From: Sarah Burrow <Sarah.Burrow@arun.gov.uk>
Sent: 22 January 2021 16:38
To: Maria Tomalova <Maria.Tomalova@arun.gov.uk>
Cc: Planning.Responses <Planning.Responses@arun.gov.uk>; Kerry@ss-p.co.uk
Subject: RE: Y/142/20/DOC

Engineers Comments Regarding Surface Water Drainage

At this stage it is not possible to recommend that conditions 10 or 11 imposed under Y/121/19/PL are discharged. I have the following comments that require addressing before I can recommend discharging the conditions:

Soakaway Test No. SA203 - Test 2
Contract: Yapton
Contract No. J20-043

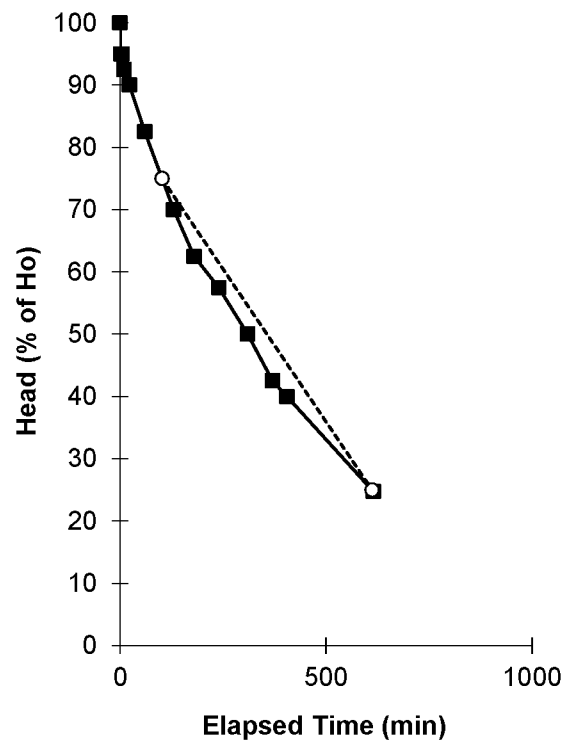
On the basis of the above, it is recommend that further infiltration testing is completed now, to capture the infiltration rate in the correct period. This can be just one test pit in the location with the slowest rate (SA203 – 2.97×10^{-6} m/s) results can then be compared to the autumn testing. Please ensure that the testing is no deeper than 0.6mbgl, assuming groundwater is evidenced below this level.

3. The calculations do not use the slowest infiltration rate for the site of 2.97×10^{-6} m/s (SA203). These will need to be adjusted irrespective of the outcome of points 2 and 3.
4. Please confirm that the calculations include the access road for the impermeable area. They state 'car park + driveway + roofs', the same is stated for the permeable car parking areas. Please supply an impermeable area plan as per the Drainage Checklist.
